Application No: R/223/24/PL
Site Address: Rustington Manor Hotel And Restaurant 12 Broadmark Lane Rustington BN16 2HH
Description of works: Demolition of existing pair of garages and erection of a three-bay car port with 1 No. studio flat (use class C3) above. This application is in CIL zone 4 (zero rated) as apartments.

Thank you for your internet representation made on 6th December 2024 which has been recorded as no objection with the comments as follows:

JOB	CHECKED
Rustington Manor Hotel 12 Broadmark Lane BN16 2HH	LRA
CLIENT	DRAWN
Mr P Leach	ES
DRAWING	DATE
Floor Plans Proposed	24.10.16
	SCALE
	1:50 @ A0
	REVISION
	NUMBER
	7084/020

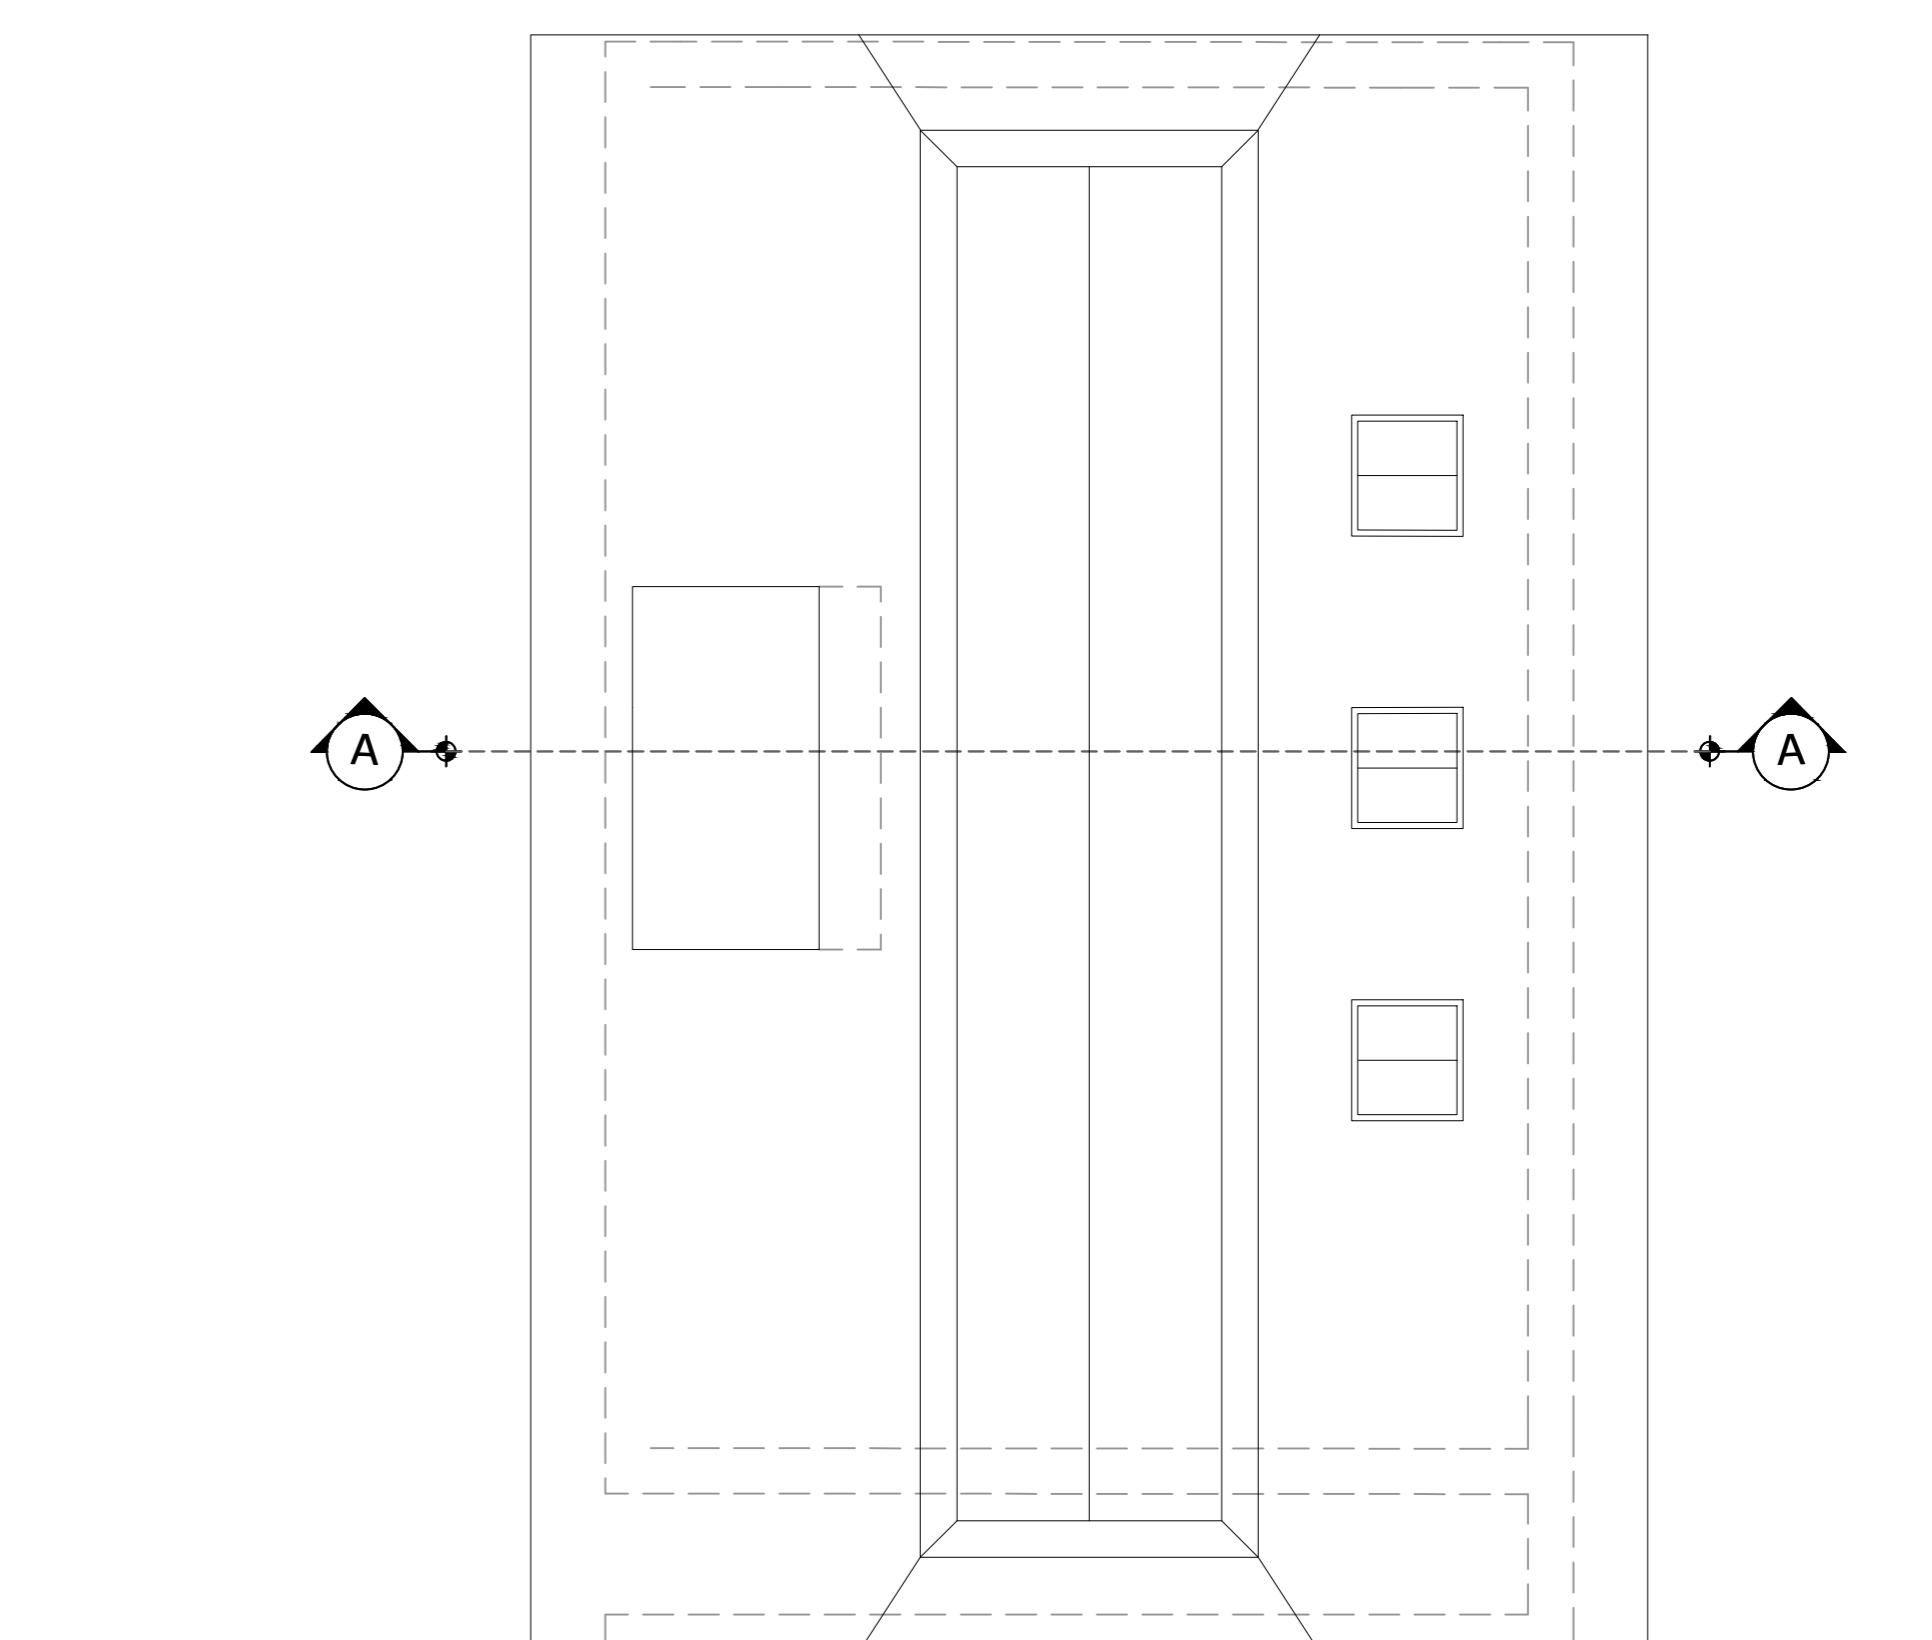
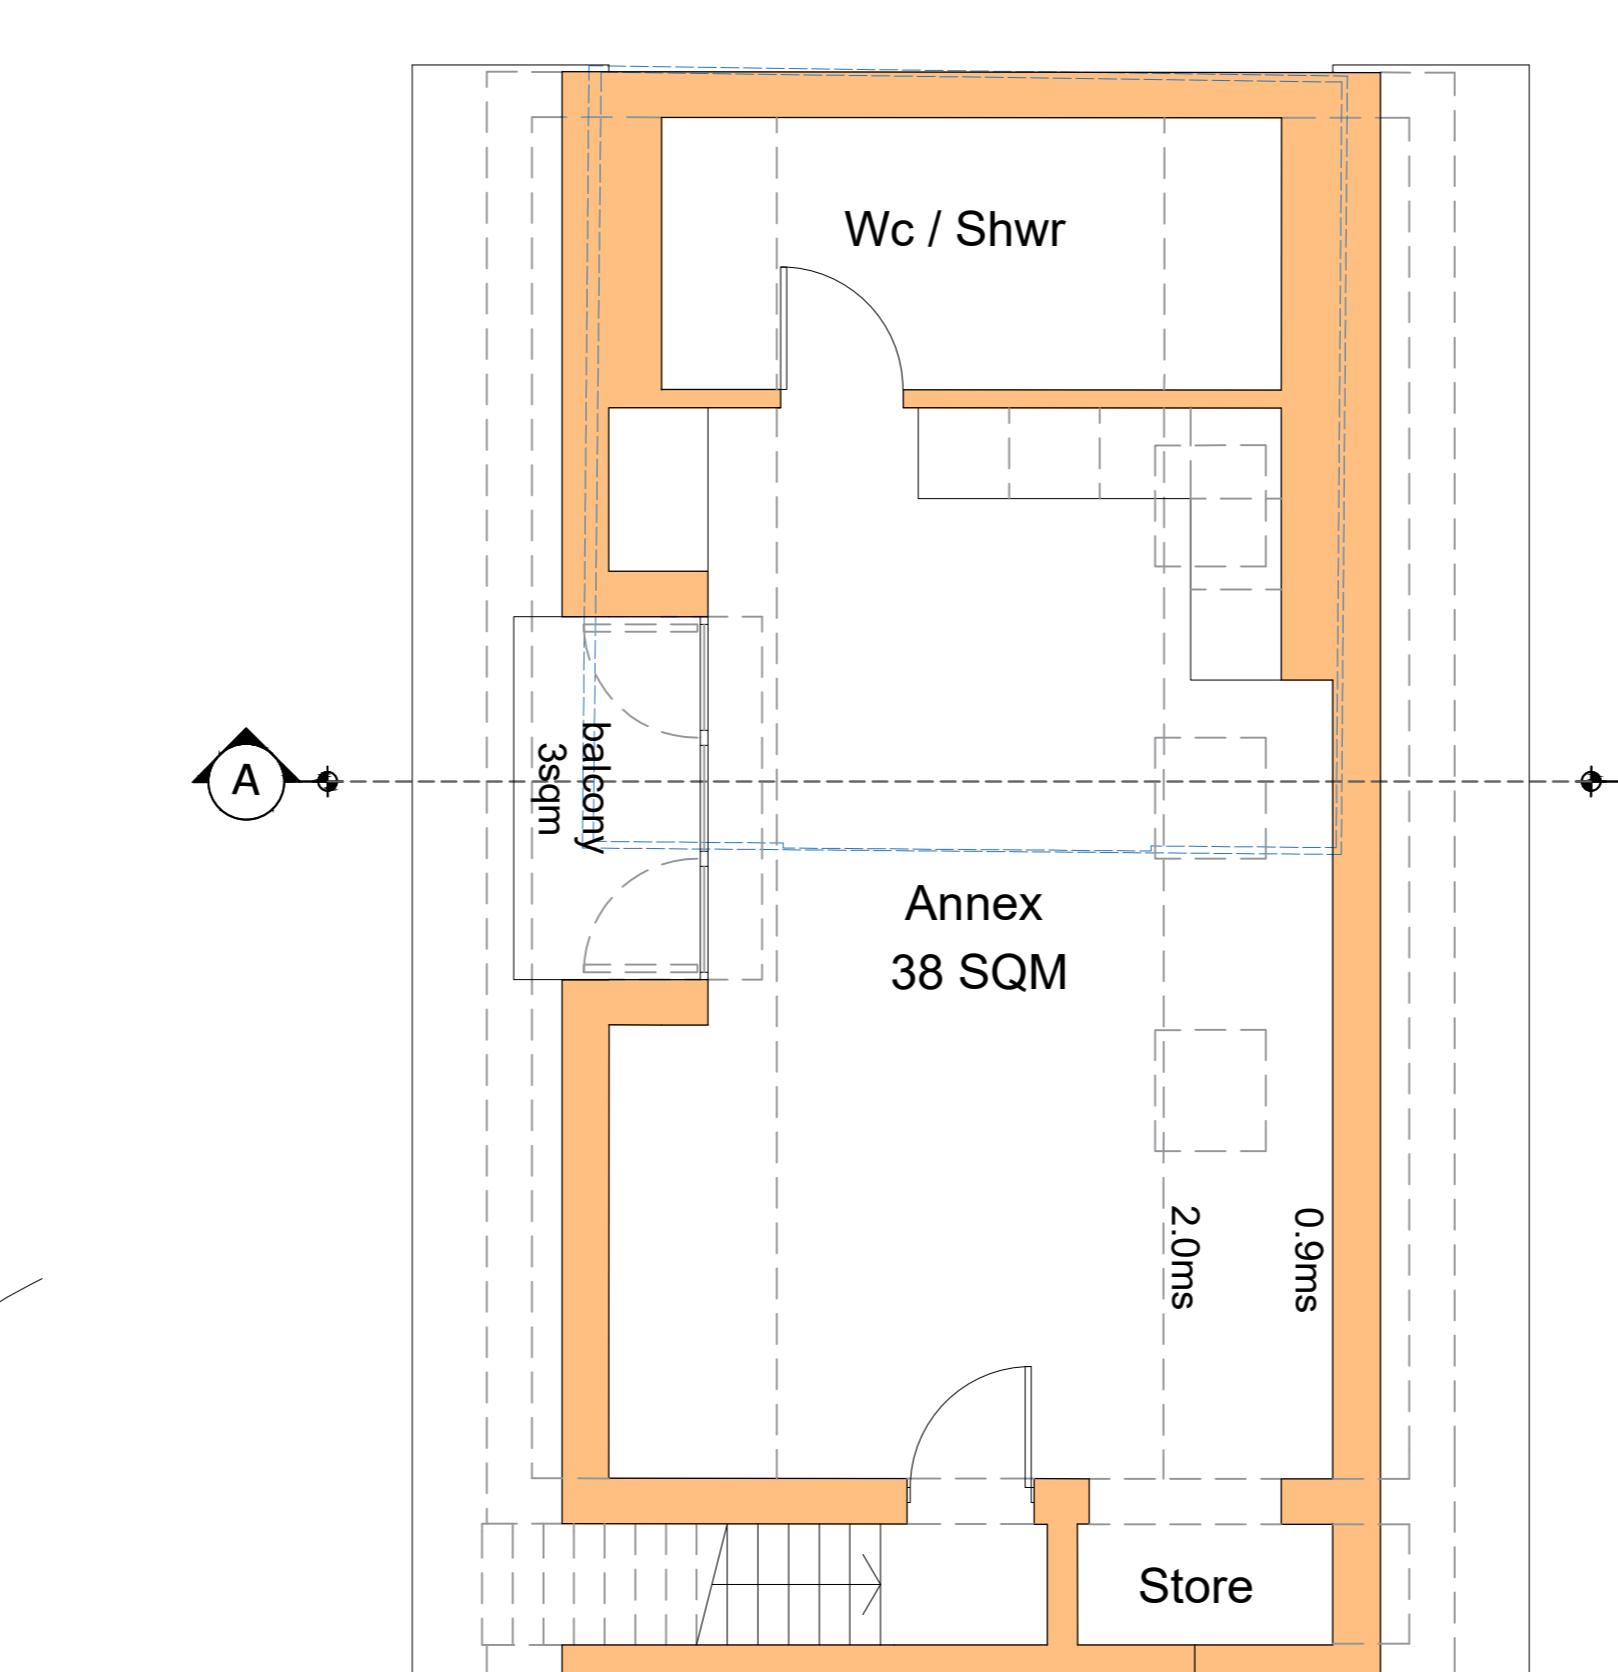
looking at the floor plan directly opposite the entrance to the car ports appears to be a dustbin compound containing 9 bins, this will be in direct line of sight to passersby, I request that doors be fitted to hide the bins from sight and as a barrier to the many foxes that live in this area
